**Re: Family Dollar Store, 7700 Sage Rd. SW, Traffic Circulation Layout
Engineer's Stamp dated 01-08-13 (M10-D019A)**

Based upon the information provided in your submittal received 01-09-13, the above referenced plan cannot be approved for Building Permit until the following comments are addressed:

FAMILY DOLLAR
F.F. =
5079.00

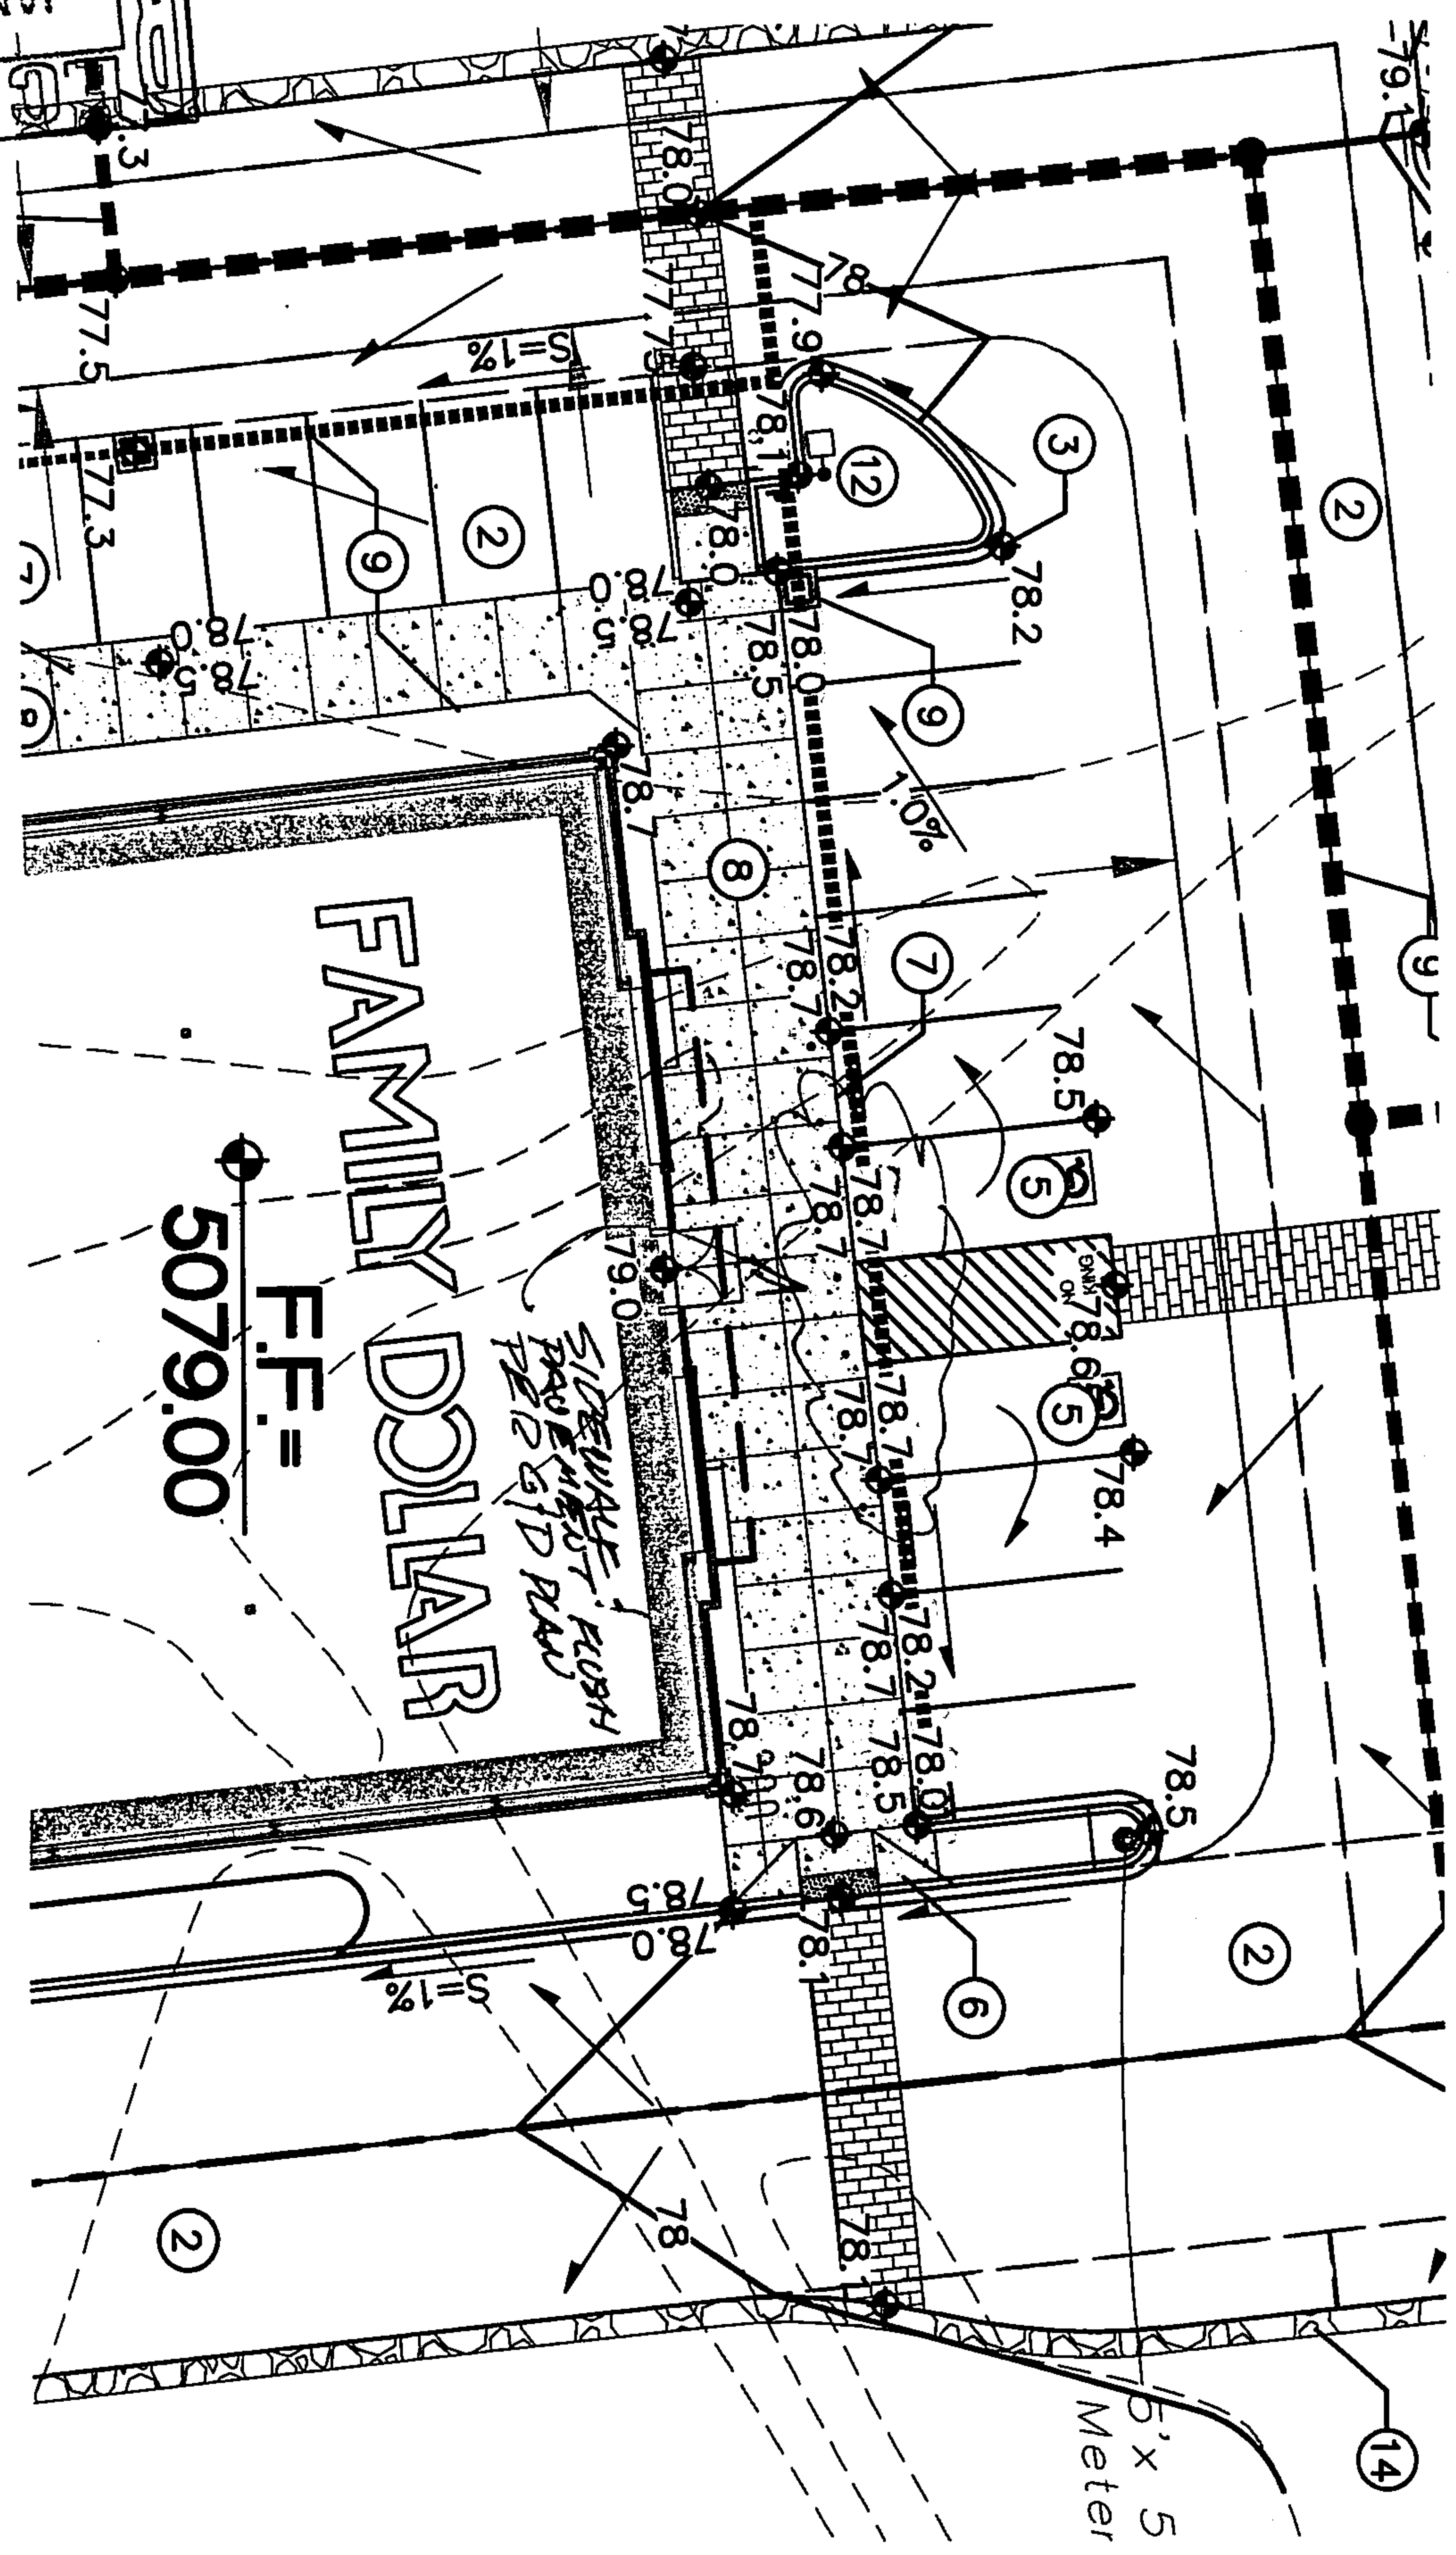
1. Please show a vicinity map on the site plan.
2. Please provide a legal description on the site plan.
3. Please include two copies of the traffic circulation layout at the next submittal.

4. The improvements on Sage Road are shown as existing; however, this infrastructure has not yet been built. Please provide additional information. Will these items be built under work order? Is there an infrastructure list associated with this site? Is there a recent replat associated with this site?

5. Please place the proposed sidewalk at the property line and define width.
6. List the width and radii of the proposed turnout.
7. If the site has left turn access, the drive pad has a 36-foot minimum width. Please refer to *Development Process Manual* (DPM) Ch.23 Section 6 for regulations regarding drives with median access, curb return construction, single entrance/exit widths, and striping and signage.

8. Please provide pavement markings to indicate vehicle movement. If there is a left turn egress, please indicate with aisle striping and directional arrows. Refer to DPM Ch. 23 Section 6.10.

9. Clearly show the ADA accessible pathway from the public sidewalk to the building and from the ADA parking stalls to the building. Show all ramps and provide details. If a sidewalk is flush with the adjacent pavement, please indicate this on the plan.

10. The proposed curb return at the entrance indicates a radius of 10 feet. A 25 foot radius is required to accommodate turns by refuse, fire, and larger service vehicles. Refer to DPM Ch. 23 Section 7.2

12. Show a detail of the wheelchair ramps located at the proposed driveway, or refer to the appropriate city standard.
13. Label the compact parking spaces by placing the words "compact" on the pavement of each space.

14. Clearly delineate between property lines, setback lines, easement lines and project limits. A legend to clarify line types and hatching is recommended.

15. All easements must be shown on site plan and labeled. Please provide recording information.
16. Please include a copy of your shared access agreement with the adjacent property owner(s).

17. Clearly show the heavy vehicle pathway between the public roadway and proposed site to include ingress, egress and internal circulation. The pathway cannot cross into incoming traffic.

18. Per DPM, a minimum 30 foot aisle at the rear of building needs to be provided for service vehicles. Refer to DPM Ch. 23 Section 7.8.
19. Per the DPM, the required landscaping plan must be reviewed by the Traffic Engineer to insure that traffic safety needs are met.

20. Keyed Note #2, indicating location of ADA ramps, is mislabeled in four locations with leaders to concrete bumpers.
21. Work within the public right of way requires a work order with DRC approved plans.
